MMC: FW: Shaws TCP (CMP)

Hi Nell – The following are some initial comments on the Construction Management Plans. I will likely have additional questions after receiving responses to these comments.

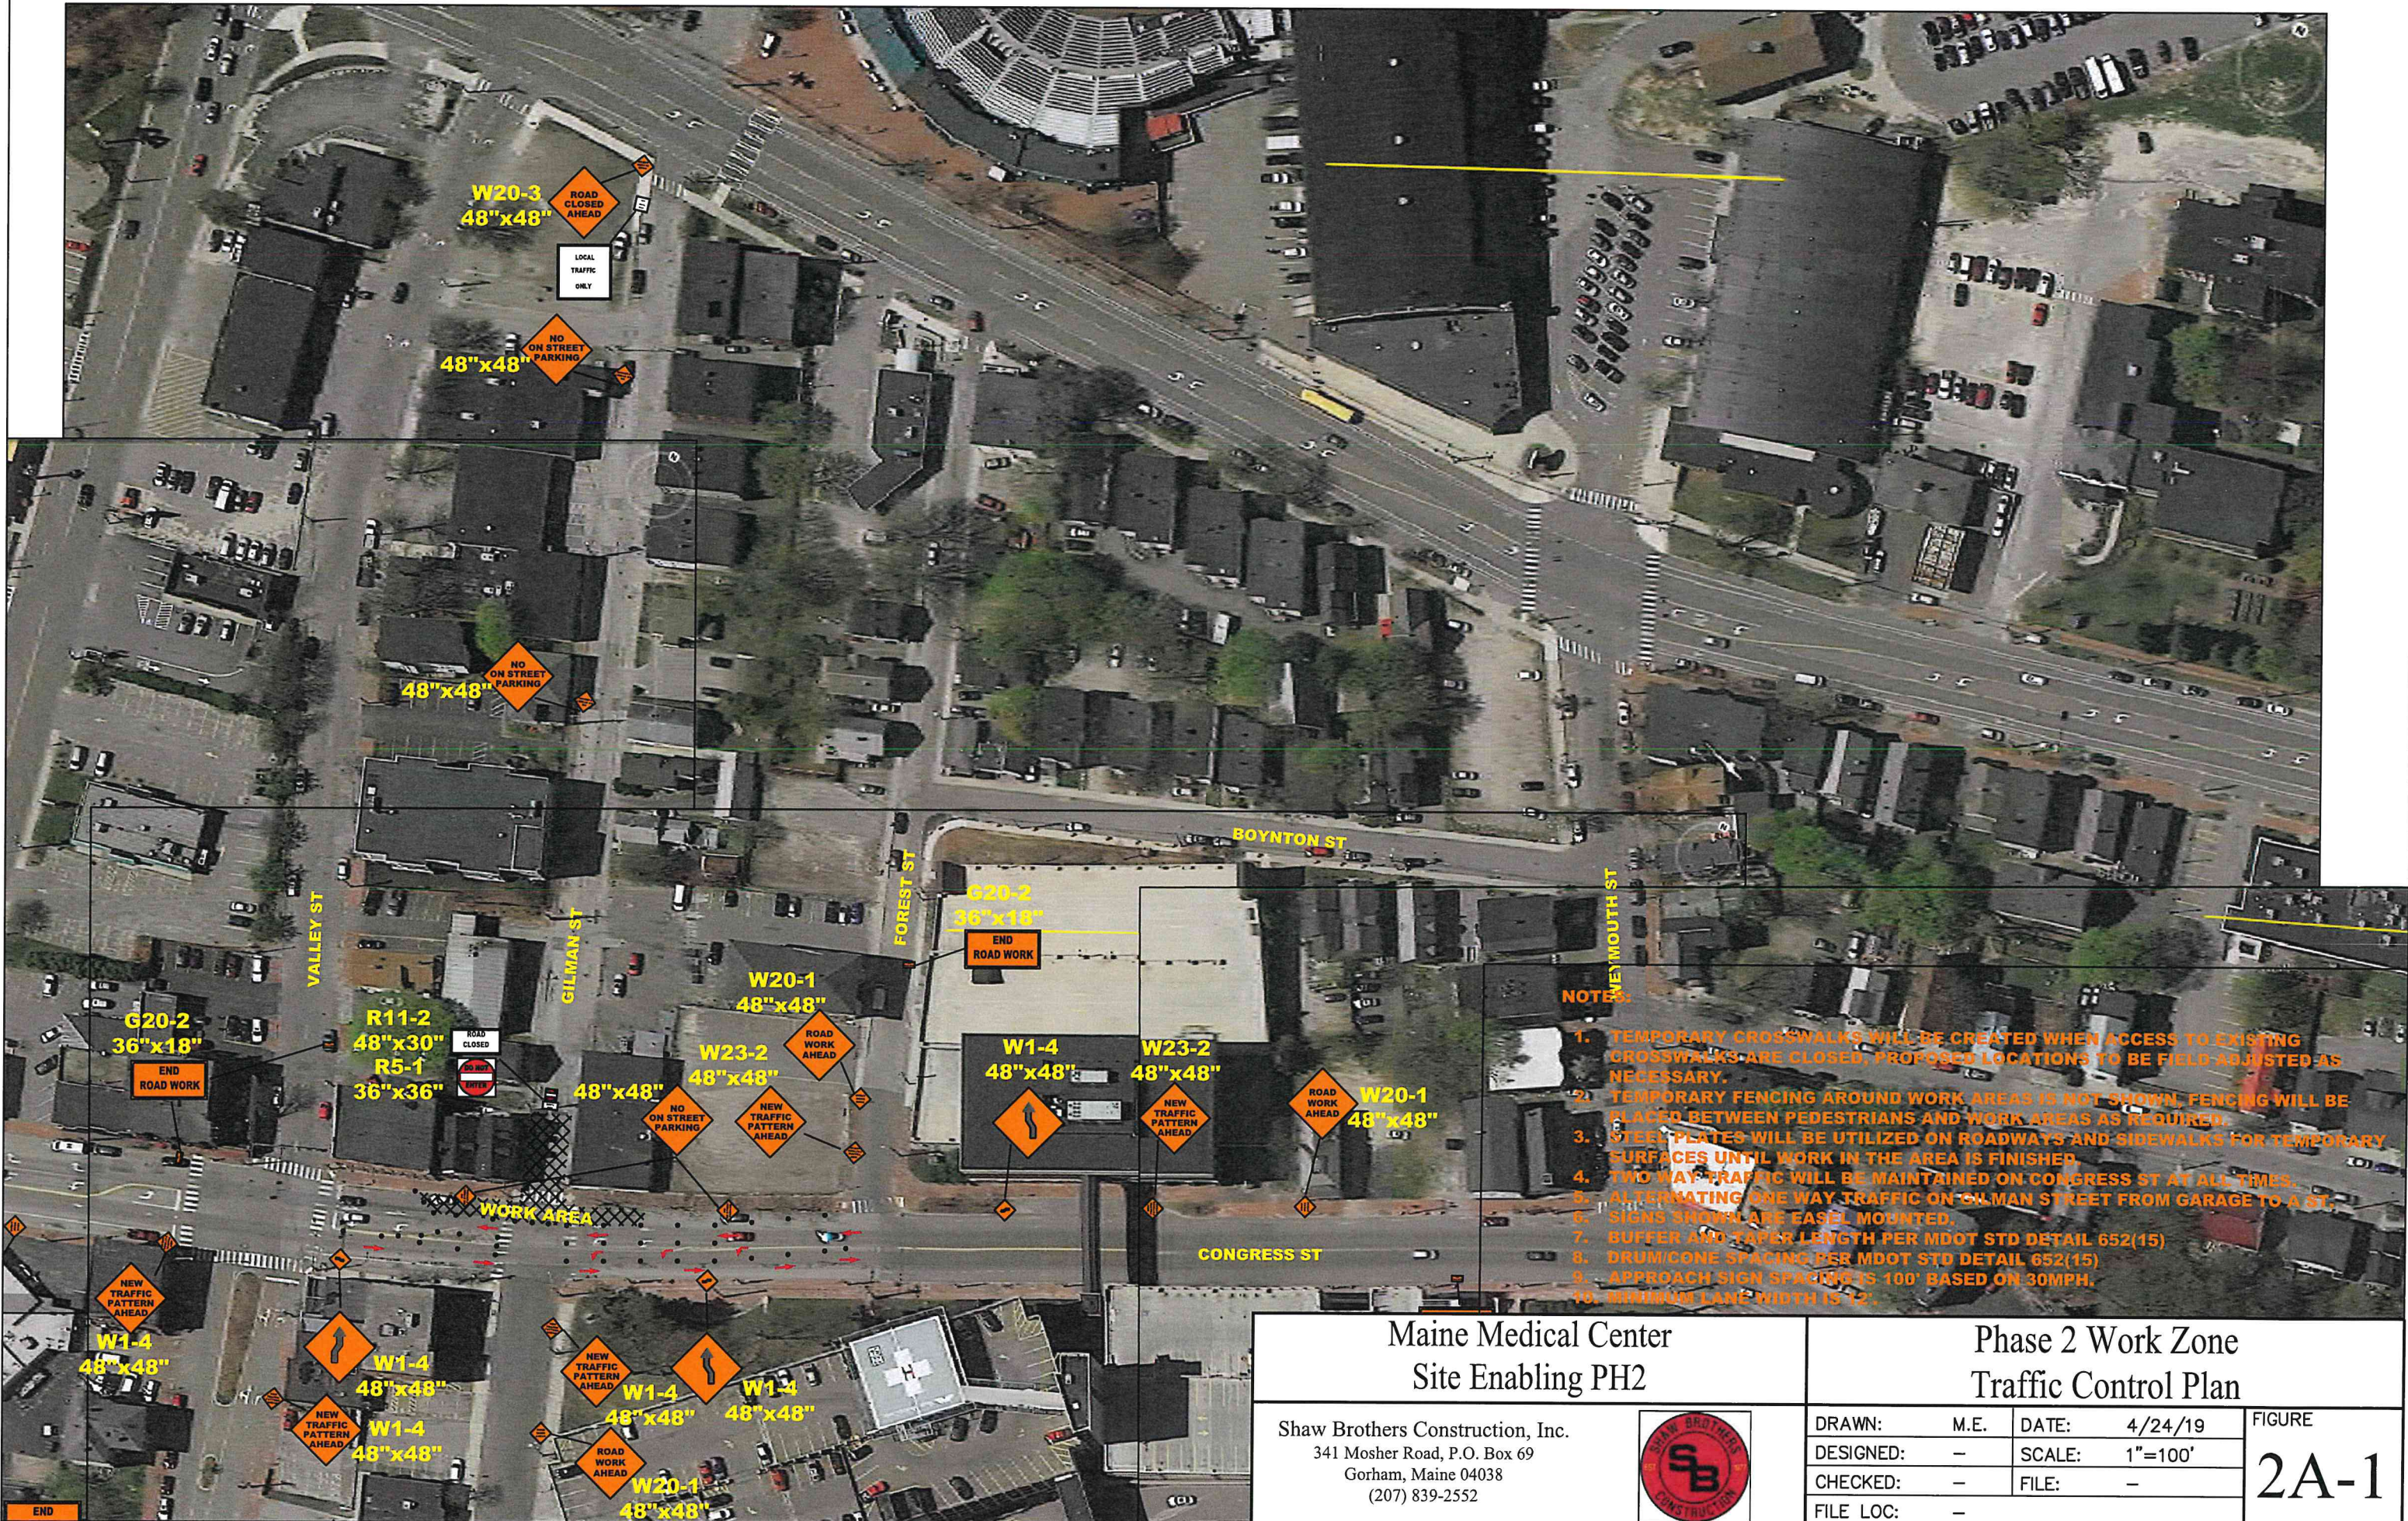
- Is the sidewalk closed on the north side of Congress at Gilman?
- How is traffic being managed on Gilman between the closure and Park Avenue? Greater detail is required.

Maine Medical Center Site Enabling PH2		Phase 2 Work Zone Traffic Control Plan		FIGURE  <b>2C</b>
Shaw Brothers Construction, Inc. 341 Mosher Road, P.O. Box 69 Gorham, Maine 04038 (207) 839-2552		DRAWN: M.E.	DATE: 4/24/19	
		DESIGNED: -	SCALE: 1"=100'	
		CHECKED: -	FILE: -	
		FILE LOC: -

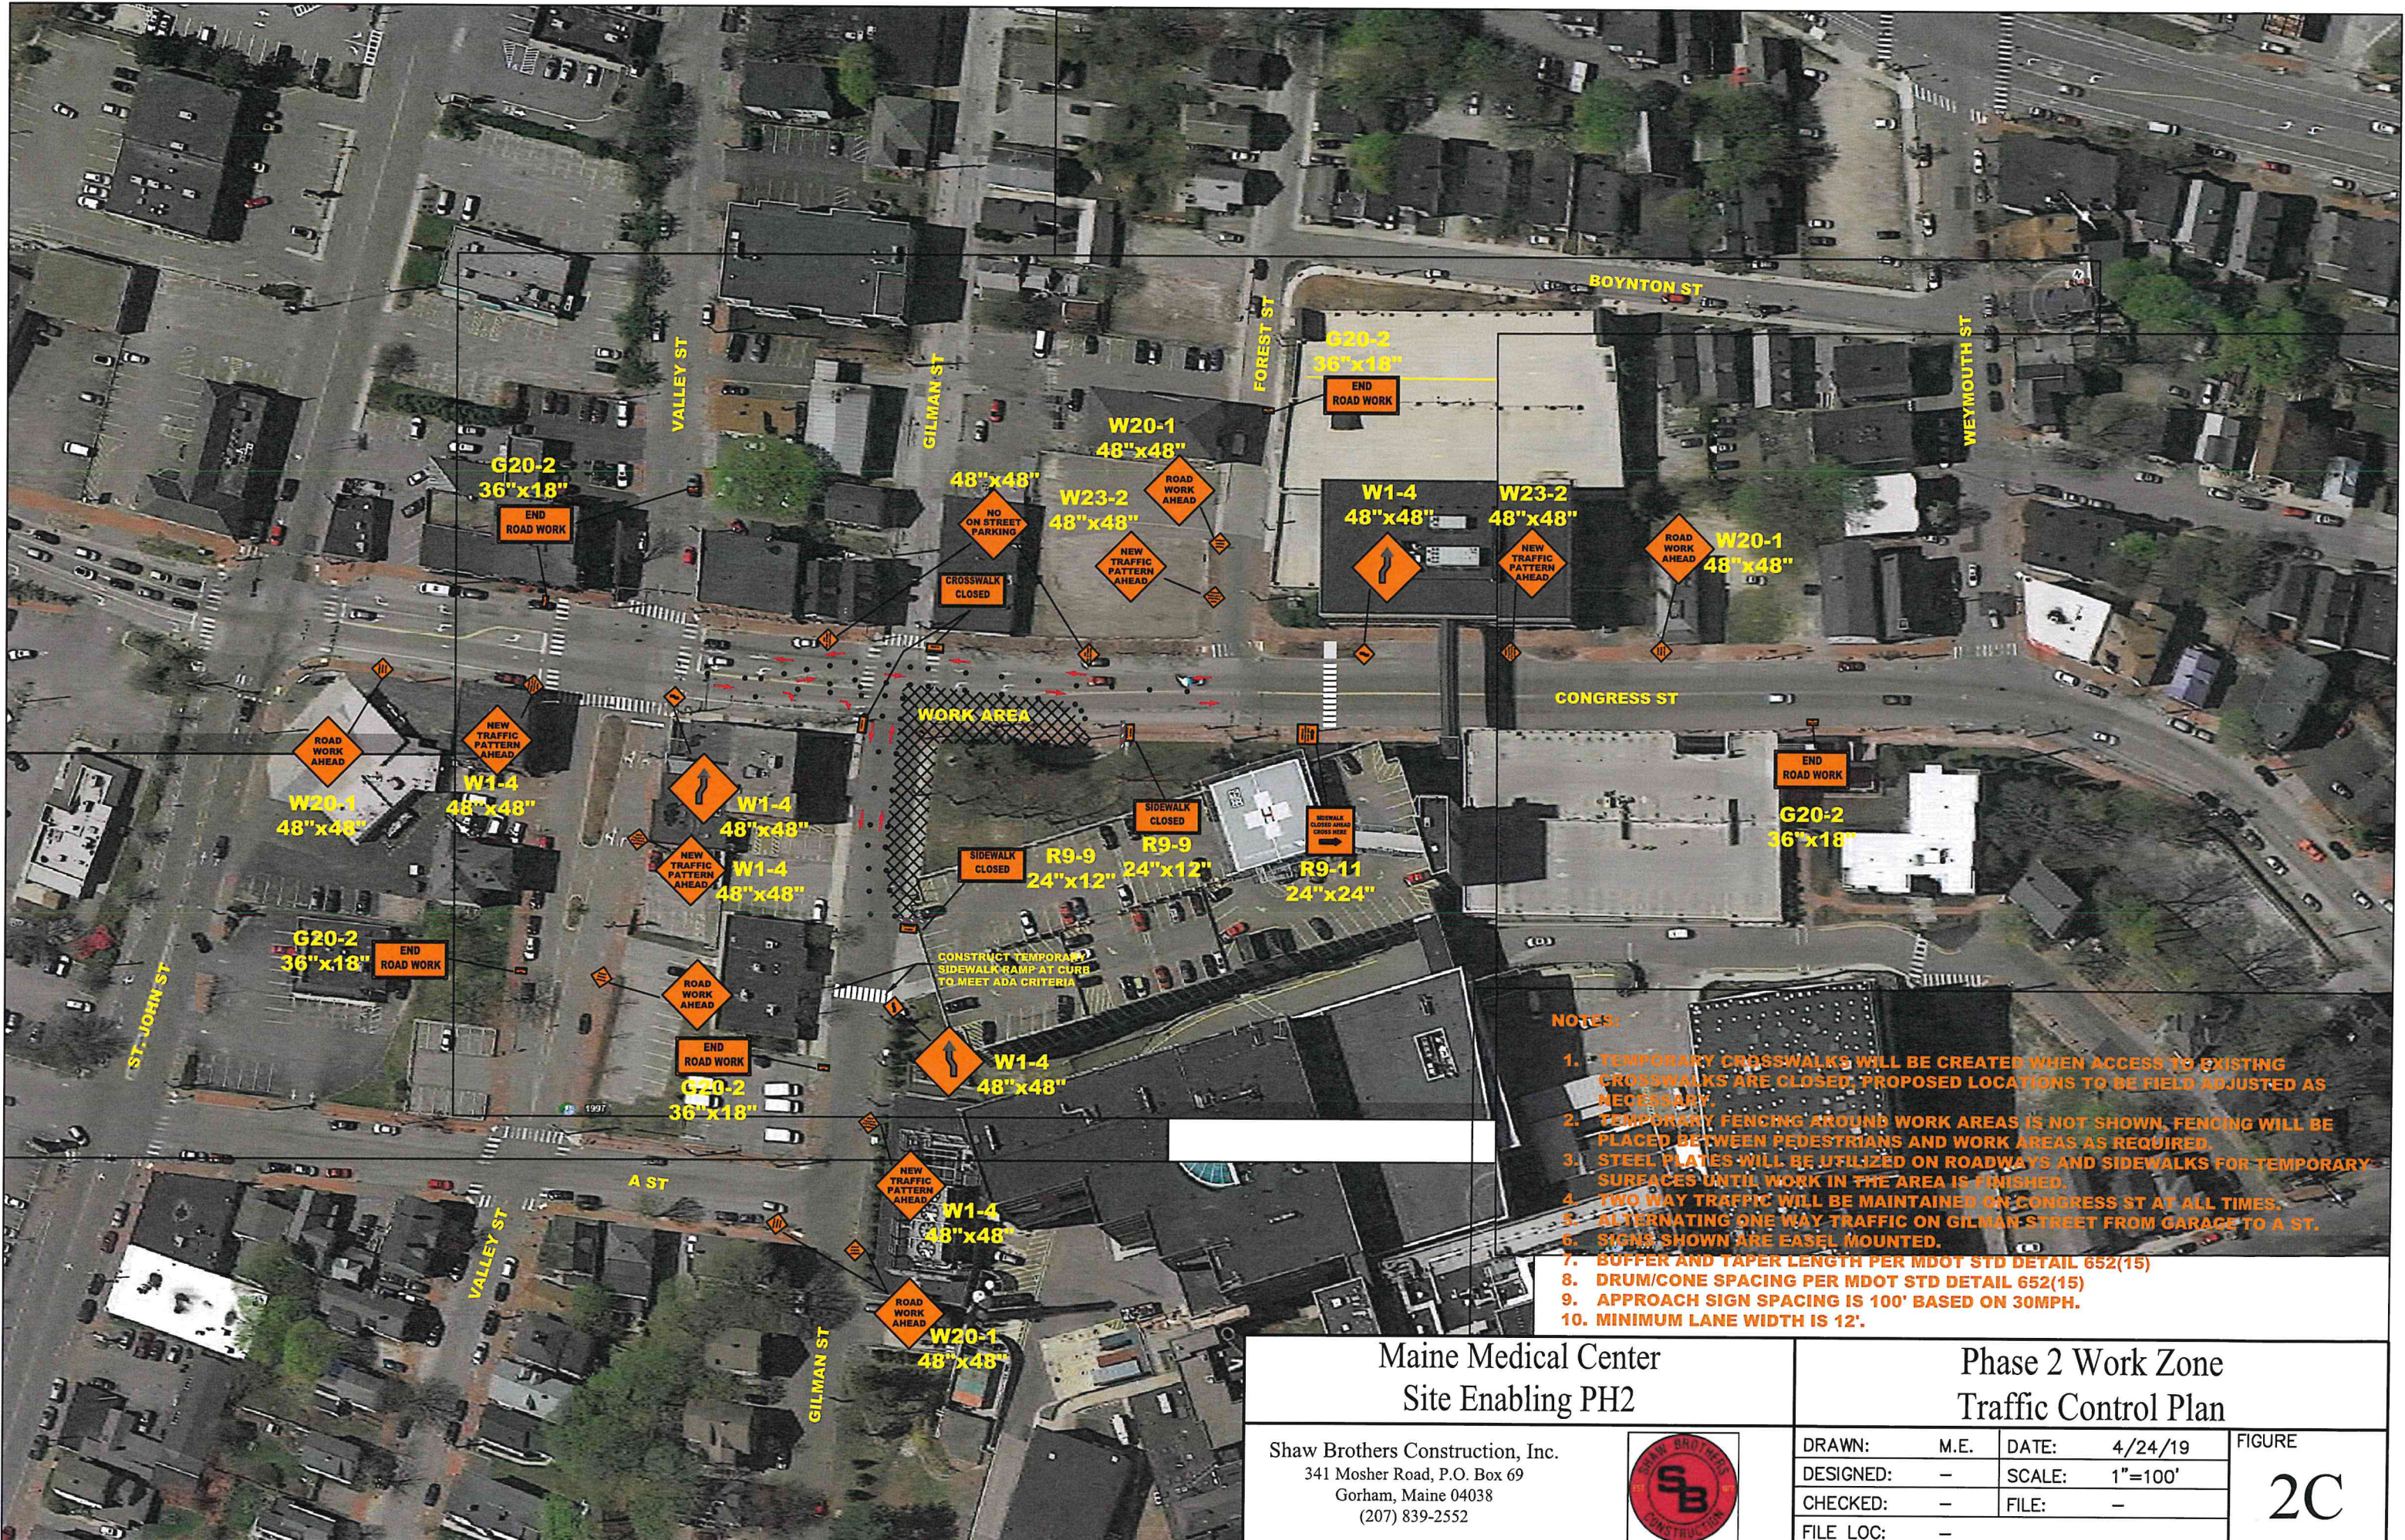
- I am concerned about pedestrians crossing on Congress Street west of Gilman, where multiple lanes and barrels are provided. Greater detail or adjustment is suggested.
